Address: Thornfield Bierley Marsh Bradford BD4 6PL

Application number: 2024/93227	
What is the application for?:	Variation condition 2 (plans) on previous permission 2020/94345 (APP/Z4718/W/21/
Address of the site or building:	land at, St Luke's, Bierley Marsh, East Bierley, BD4 6PL
Postcode:	WF17 9BN

Type of comment: An objection	
Do you wish your comments to be published on the website anonymously?	No
Objection: Kirklees Public Rights of Way (PROW) Comment - lack of. It was with some surprise and concern, that I read the Consultation Response from Kirklees PROW re. separate, but nearby application 2024/92849, at Cross Gables, Bierley Marsh, stating: Public footpath Spenborough 6 (SPE/6/20) runs along the private vehicular access road known as Bierley Marsh. It is observed that vehicular access to the land / garage will be via the existing curtilage of Cross Gables and using the existence entrance from Bierley Marsh. No new vehicular access is proposed. We have no objection to this development. I ask that Kirklees Public Rights of Way team make a formal comment on application 2020/93227, former application 2020/94345. This current application shows two new access points, onto an

client name			
Owens Developments Ltd			
project			
New Dwellings - Land at St Lukes.			
drawing			
Proposed Site Layout			
project number		plot date	
19/157		24/11/20	
drawing number		scale	
104		1:200 @A2	
rev		issue status	
D		Planning Submission

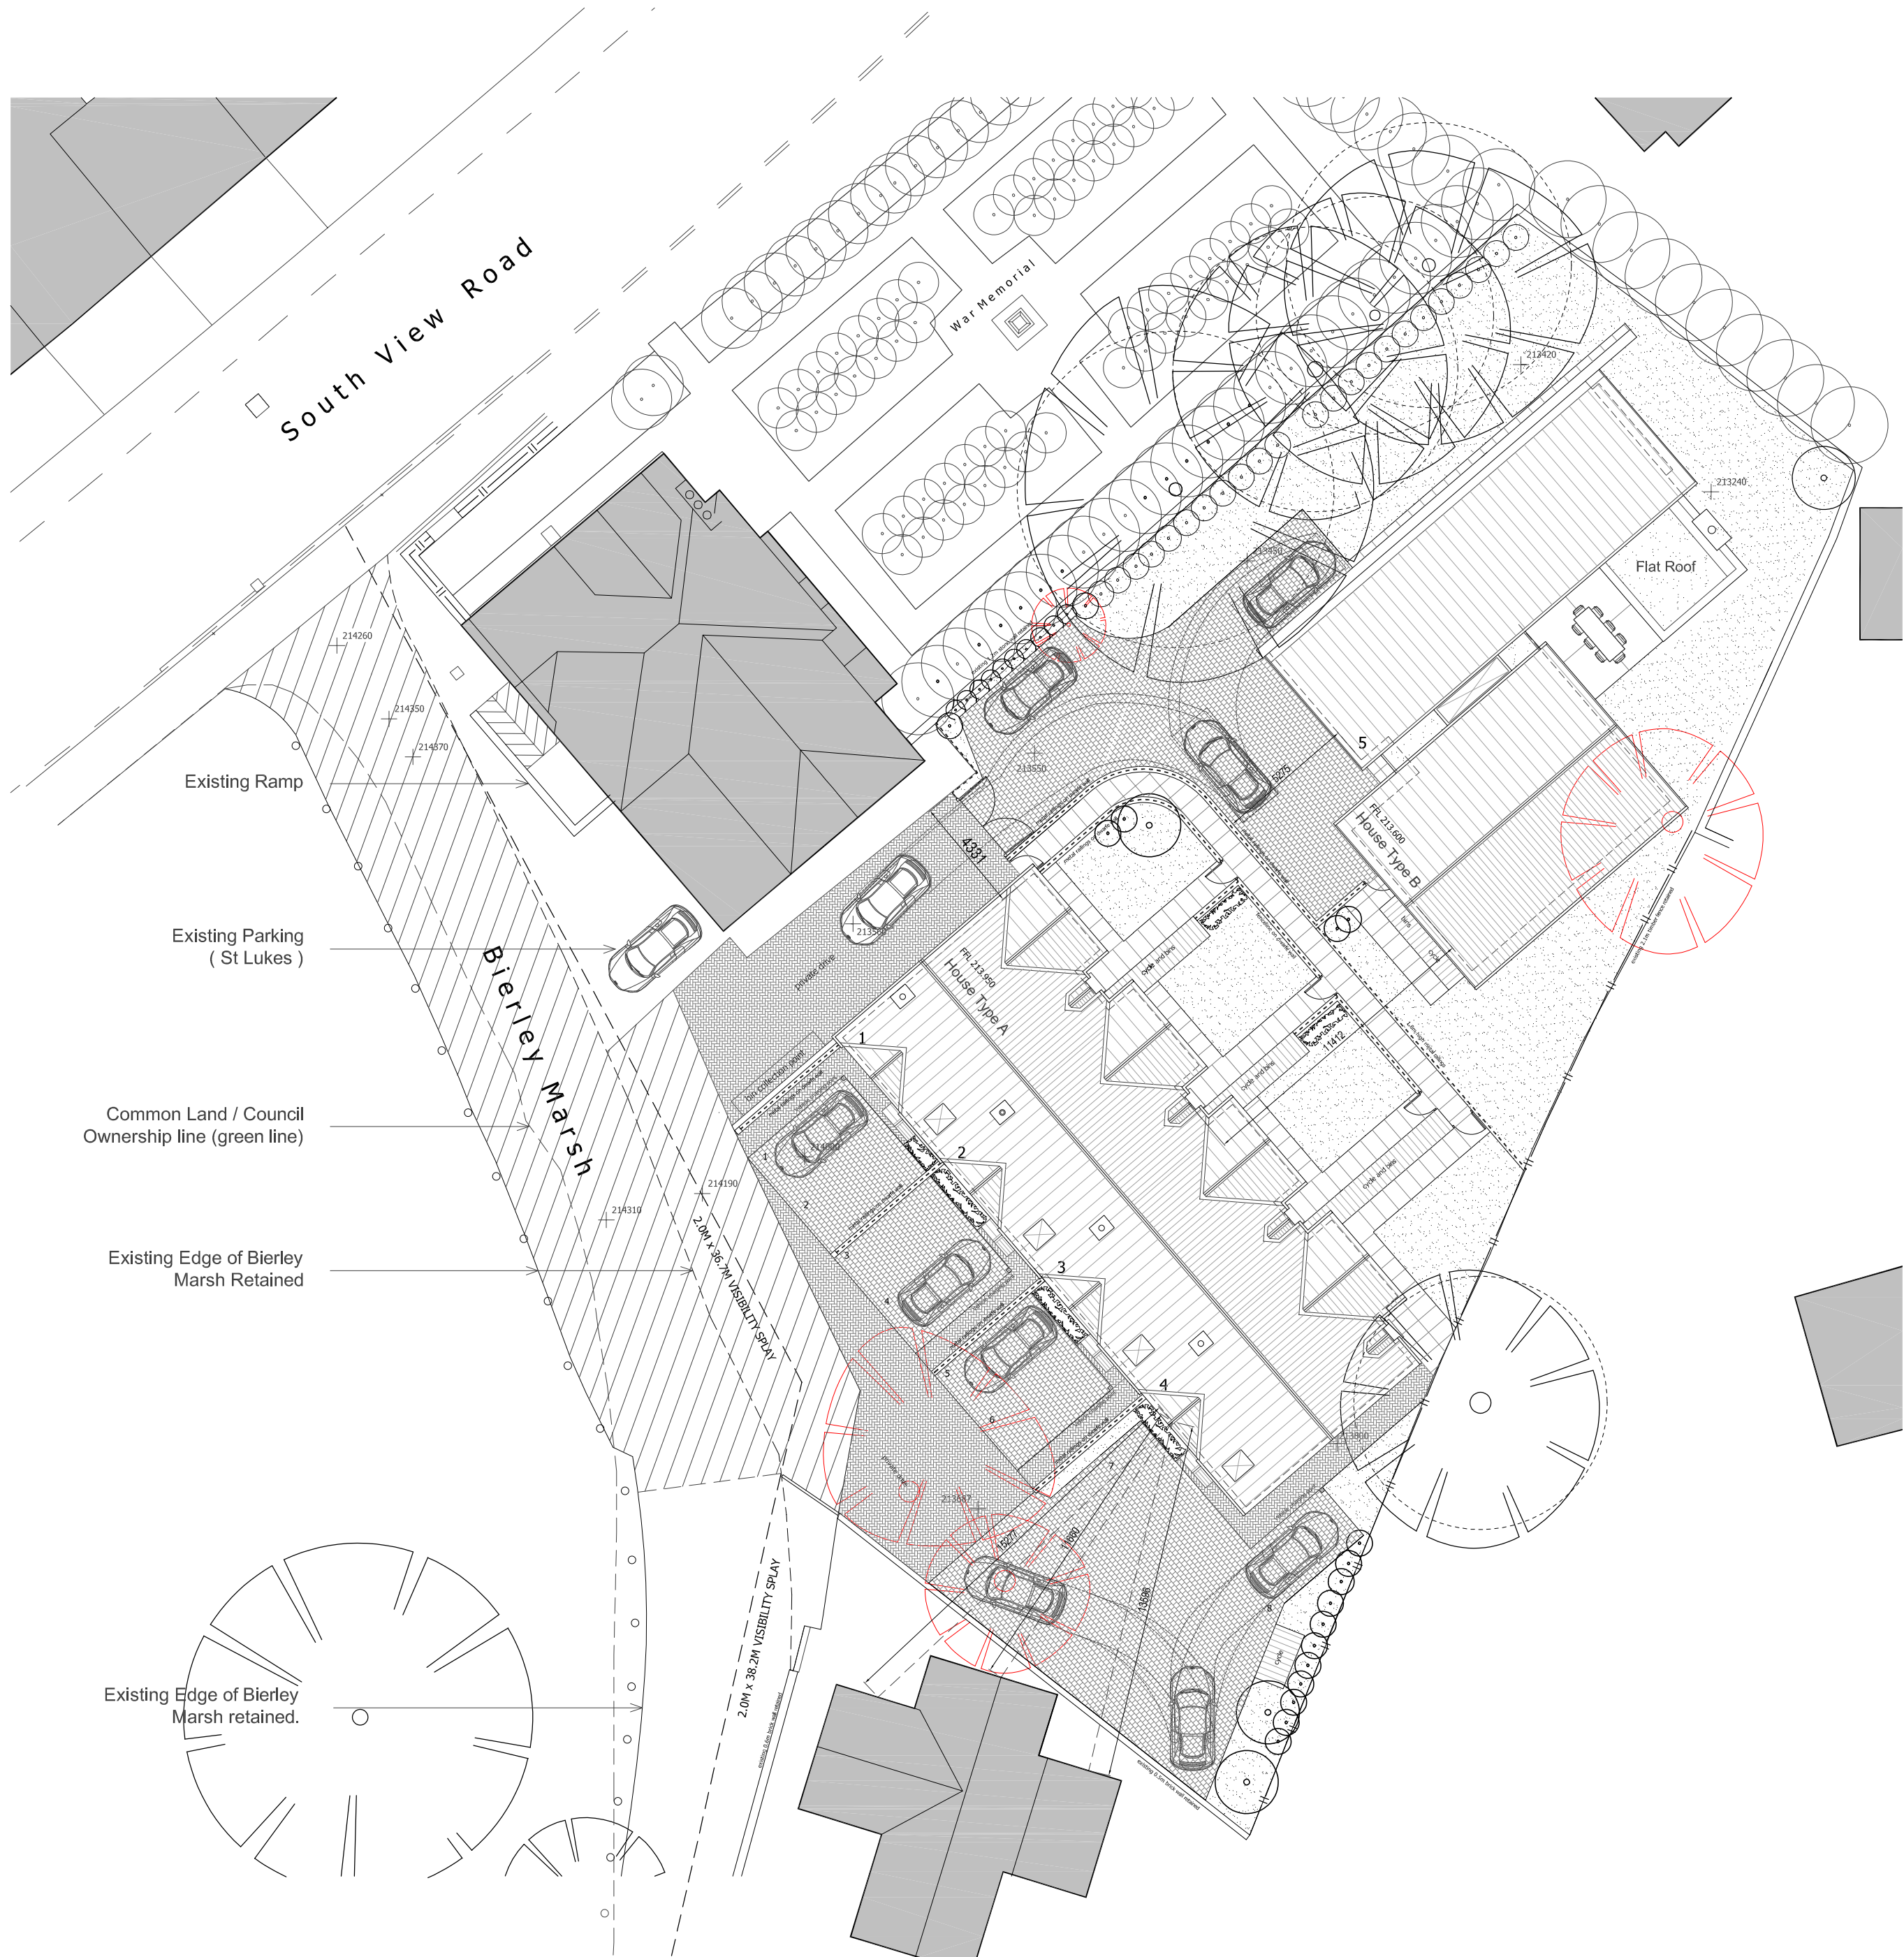
The developer has specified his intention to modify this roadway. His plans show he wants to widen the road from South View Road down to Cross Gables, taking land from Bierley Marsh Green (UGS) which is totally unacceptable.

His plans show measurements which are totally wrong and are exaggerated by as much as a meter in some places. The discrepancy comes about over the confusion of the line of the boundary, something clearly Kirklees need to address.
